RE: USM Woodbury Campus Center PV Array Project, Portland, ME
RTD 14-1521

As requested, an inspection was performed on the USM Woodbury Campus Center PV Array Project located in Portland, Maine on November 18, 2014.

The inspection consisted of a Visual Inspection of Grillage Framing and PV Support Framing bolted connections and welded connections.

A4 GRILLAGE FRAMING PLAN SCALE: 1/8" = 1'-0"

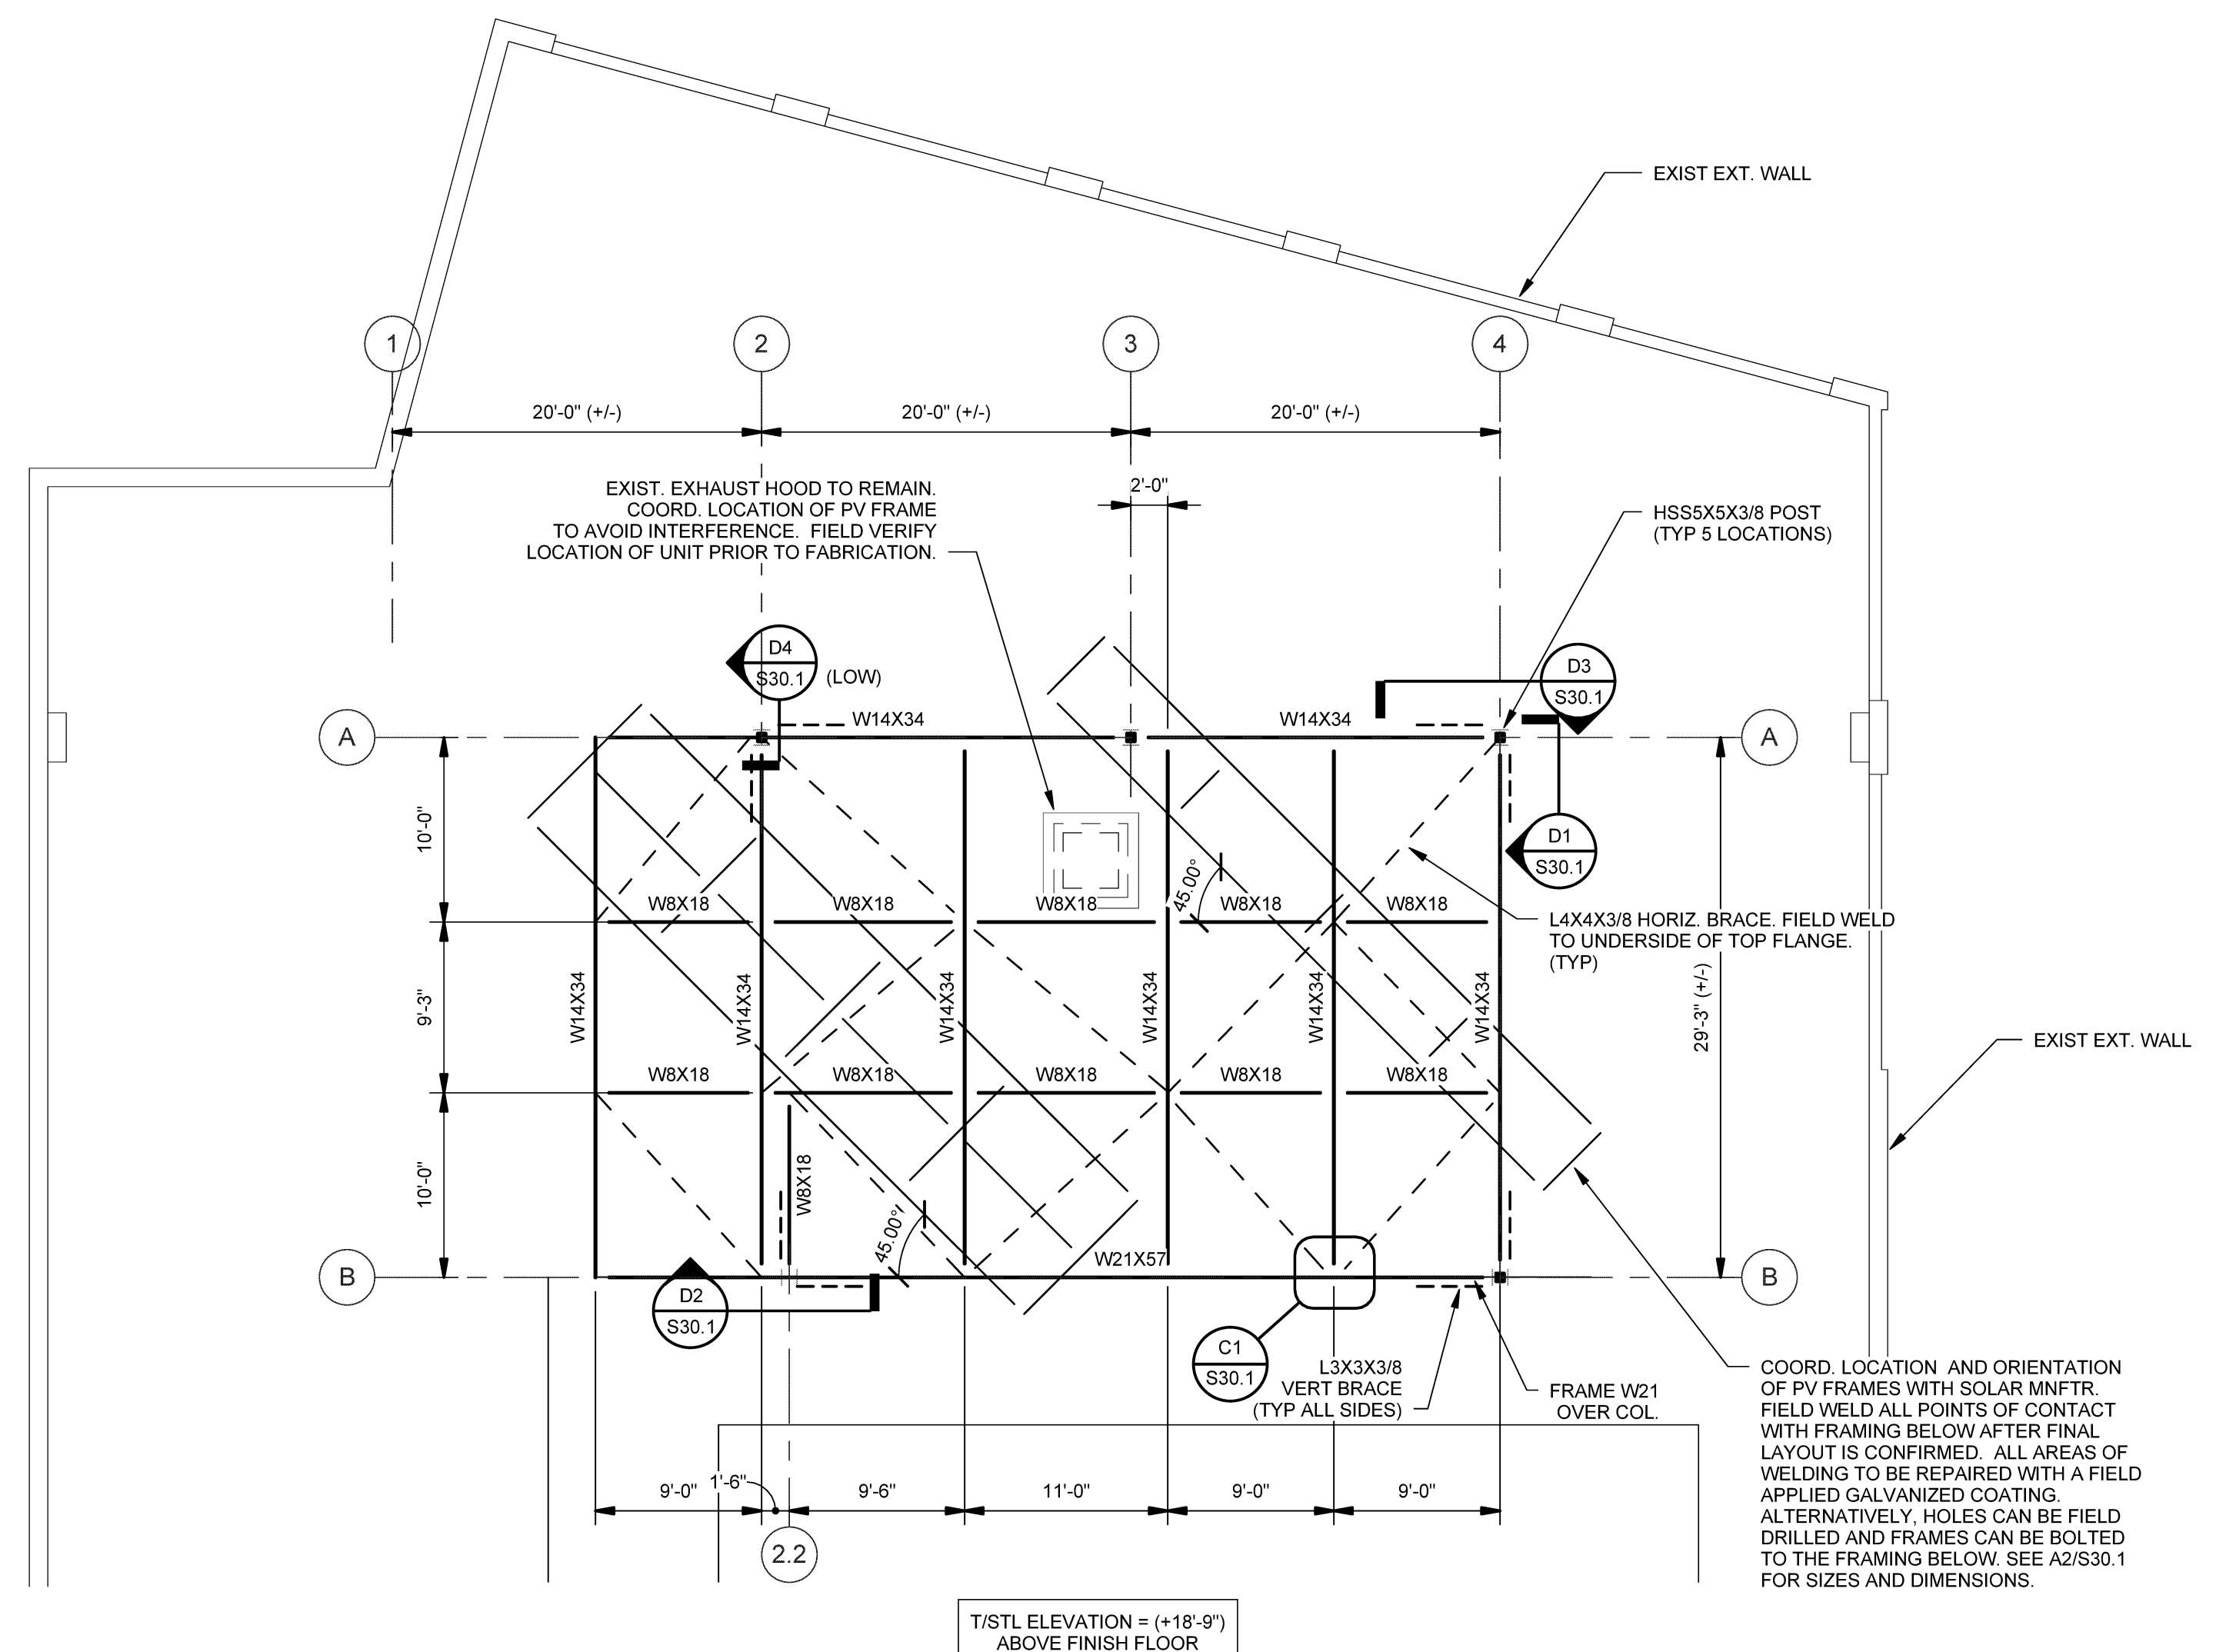
There are a total of 44 welds attaching the 4X4X 3/8 angles to the beams. Of these, 34 welds were found to be rejectable. The welds exhibited overlap, poor profile and were undersized. The 34 welds are numbered 1 thru 34. The cause of rejection(s) is marked at each location. The welds found to be acceptable are marked "OK".

Please find attached report on weld re-inspection. All welds have now passed inspection.

Visual inspection was performed on November 25, 2014 at the University of Southern Maine Woodbury Campus Center; Phase II – PV Array. All inspection performed was In Accordance With AISC 360-10 and AWS D1.1. This visit was for Re-Inspection of weld repairs to 4 x 4 x 3/8 attachment angles to the beams. Thirty four welds were rejected on a previous visit and are now acceptable to the applicable drawings and codes.
